Your ref: 3/2024/0595

Date: 21 March 2025

Location: 5 Mersey Grove Clitheroe BB7 2FG

Proposal: Regularisation of change of use and conversion of garage to form dog grooming salon. Operating hours 9am to 7pm Monday to Friday and Saturday 10am to 4pm.

PROPOSED GROUND FLOOR PLAN

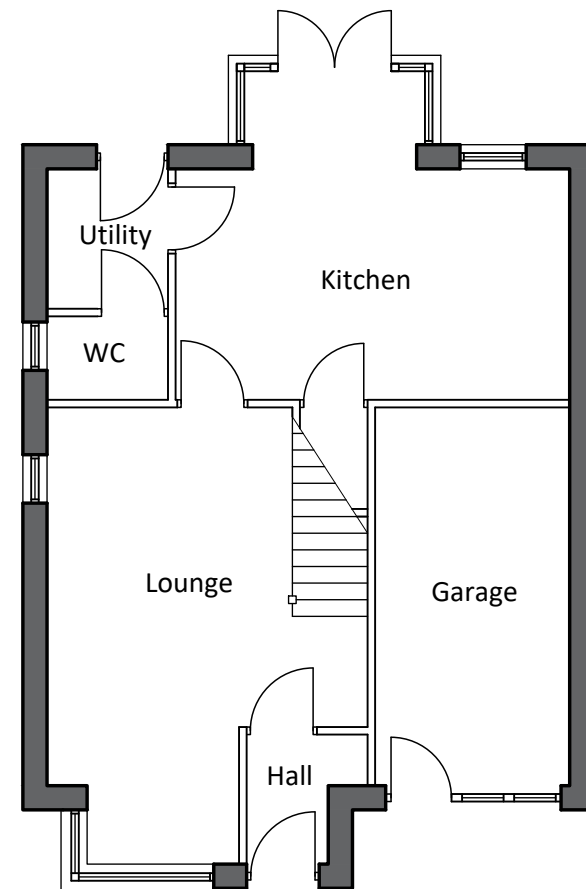
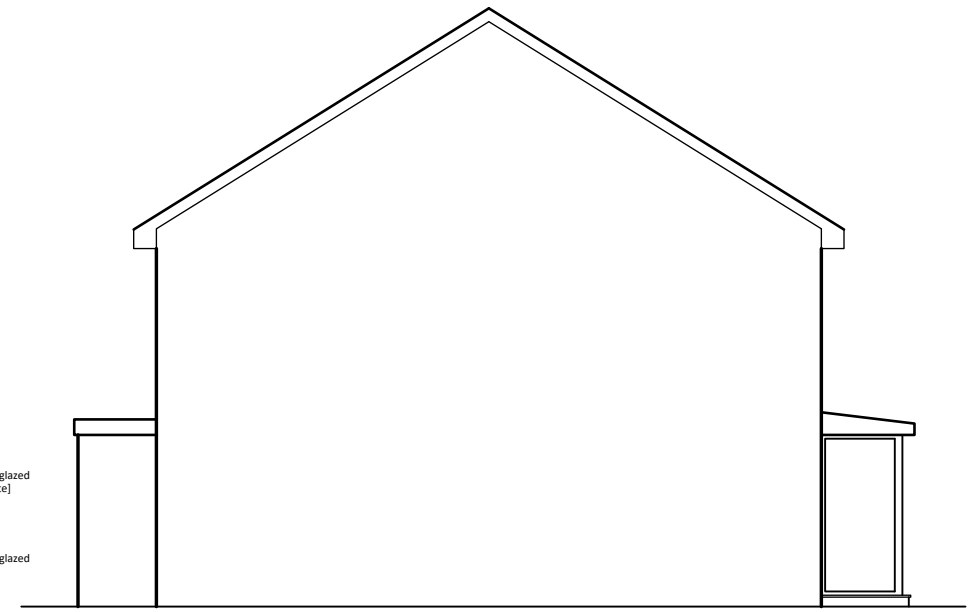
Whilst no parking plan or information relating to the number of bedrooms within the dwelling has been provided, the LHA would remind the applicant that a 2-3 bedroom dwelling should provide 2 off street parking spaces and a 4+ bedroom dwelling should provide 3 off street parking spaces in line with the LHA's guidance as set out in the Joint Lancashire Structure Plan.

It is noted that the applicant plans to have only one client scheduled at a time, the LHA would look for one additional parking space to be created alongside the required parking provisions for the dwelling to ensure that no vehicles are parked on the road. A 10 minute break between clients should be implemented to ensure only one vehicle associated with the business is present at any time to avoid any conflict within the road and the parking area.

As such the LHA would look for a parking plan to be provided before we are able to fully determine the highway impacts.
